**M54 to M6 Link Road
TR010054**

**8.8 LIU(K) Draft Statement of Common
Ground with Nurton Developments
(Hilton) Limited**

DESIGN SPEED N/A  
(WORK No. 28)  
ACCOMMODATION OVERBRIDGE  
LONGITUDINAL SECTION CH. 0m - CH. 510m  
SCALE @ A1 - HORIZ 1:1250 VERT 1:250

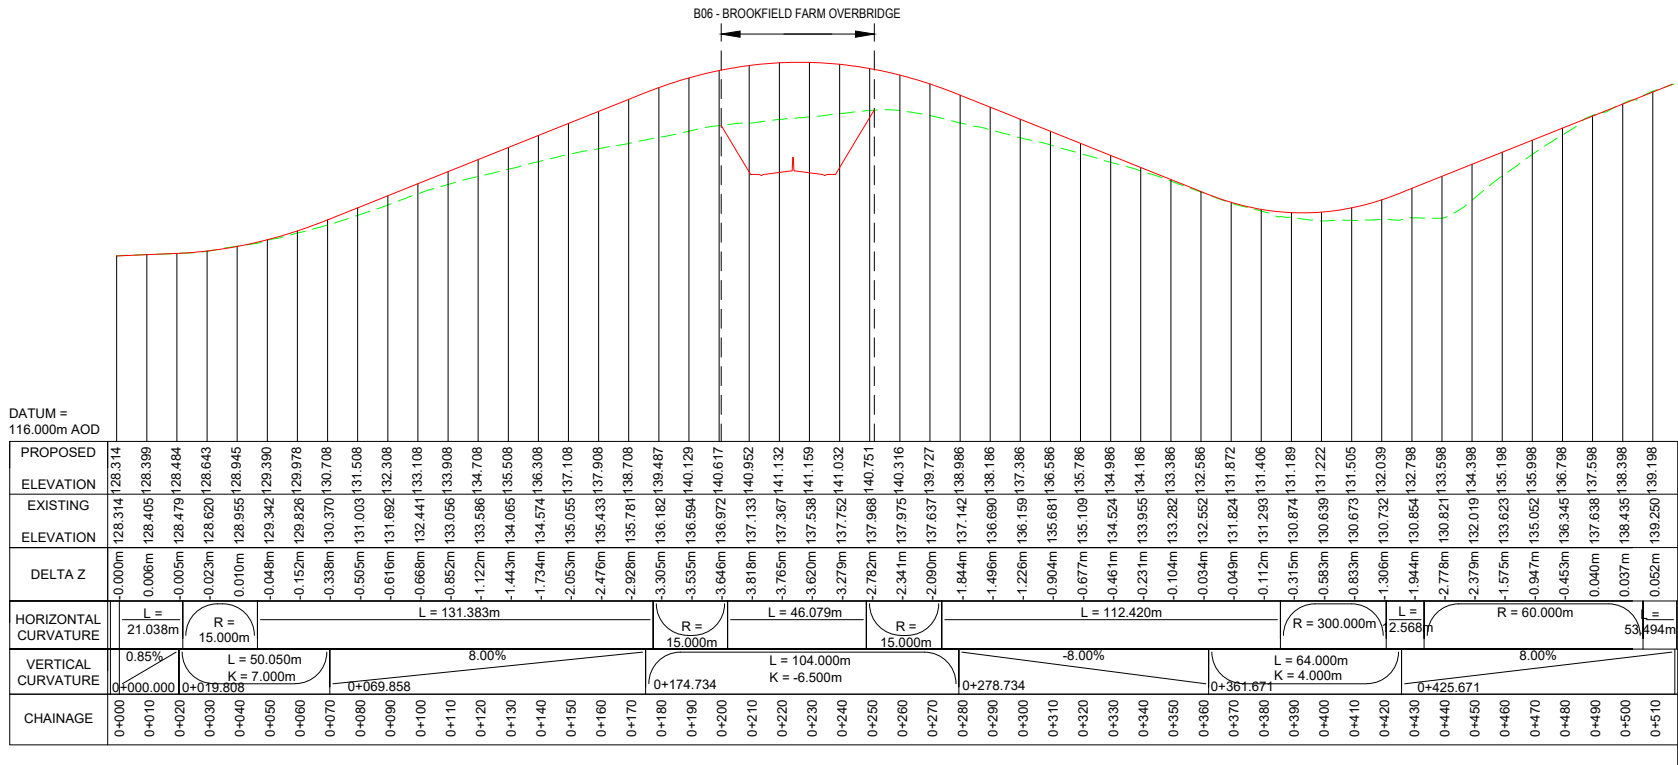
Document	Subject	Nurton Developments Limited Comment	Highways England Response	Status	Agreement likely (app) ¹	Agreement likely (IP ²)
			<p>The alternatives considered have been discussed with Nurton prior to the submission of the Application, with further correspondence prior to Nurton submitting its Relevant Representation. This includes discussions at the meeting on 2 December 2019 (see Appendix C) and a letter from Highways England to Nurton on 20 February 2020 (see Appendix D). Several suggestions for the bridge have been put forward by Nurton, each of which are explored further below.</p> <p>1/ HE understands that Nurton would like the proposed accommodation bridge to be widened to accommodate traffic that may access employment development on adjacent land, should planning permission be granted for it in the future.</p> <p>A meeting was held between Highways England and Nurton on 2 December 2019 where this matter was discussed (please see minutes in Appendix C). At this meeting Nurton explained that to</p>

Document	Subject	Nurton Developments Limited Comment	Highways England Response	Status	Agreement likely (app) ¹	Agreement likely (IP ²)
			<p>facilitate the development, the bridge should be 11.3 m wide (7.3 m road, 3 m footpath and 1 m verge) as opposed to the proposed 6 m wide bridge (4.5 m road and 0.75 m verge on either side).</p> <p>As HE explained at the meeting on 2 December, the proposed increase in bridge width would increase costs and environmental impacts and therefore cannot be justified. The bridge design proposed to be constructed is typical of accommodation bridges to enable farm machinery to access adjacent plots of land. Following discussion with the landowners, Nigel and Paul Simkin, it was confirmed that the largest road legal combine harvester requires access across this structure (4m width). Therefore, the paved width across the bridge was increased from 4m to 4.5m.</p> <p>2/ HE has also considered Nurton's request to combine the bridge at Hilton Lane and the accommodation bridge, relocating it to a location between the two. Moving the bridge further from</p>

Document	Subject	Nurton Developments Limited Comment	Highways England Response	Status	Agreement likely (app) ¹	Agreement likely (IP ²)
			<p>Hilton Lane would require construction of additional carriageway from Hilton Lane to the new bridge, resulting in significant additional costs and environmental impacts. It would require the acquisition of additional land that would not be justified in this instance. This was explained at the meeting on 2 December 2019 and in the letter from HE to Nurton Developments on 20 February 2020.</p> <p>At the meeting on 2 December 2019, HE also explained that three alternatives had been considered for the location of the accommodation bridge:</p> <ul style="list-style-type: none"> (i) a main crossing over Hilton Lane; (ii) a crossing midway between Hilton Lane and proposed location; (iii) the proposed location. <p>It was considered that the proposed location was the best balance between the diversion length of the bridleway (already at 12% of its total length against a guideline maximum of 10%) and allowing an appropriate gradient (which</p>

Document	Subject	Nurton Developments Limited Comment	Highways England Response	Status	Agreement likely (app) ¹	Agreement likely (IP ²)
			<p>will now be 8%) for the ramp up to the crossing.</p> <p>HE considers that sufficient information has been provided on the alternatives considered for this bridge and that reasonable alternatives have been considered.</p>			
Relevant Rep. 038	(c) Lack of information regarding alternatives on location and design of pond areas	<p>There is also a lack of information regarding alternatives considered in respect of the location and design of the pond areas. Having reviewed the information available, at present these conform to standard design, rather than being bespoke to a Scheme of this scale. In the absence of a consideration of alternative designs, it is difficult to understand how the adverse impacts of the Scheme have been mitigated by HE.</p>	<p>There are no proposed new ponds in the area where Nurton is recorded as having a category 2 interest.</p> <p>There are four ponds within the area Nurton was promoting through the Local Plan Review; two ponds to be created for attenuation purposes and two for ecological purposes. These are necessary for the delivery of the Scheme.</p> <p>The attenuation ponds on land being promoted by Nurton are located to the south west of Brookfield Farm and the south west of M6 Junction 11. These ponds are located at the low points adjacent to ditches to allow the outfall to drain to the existing ditches. The ponds are in the optimal location, with the</p>	Under discussion	Medium
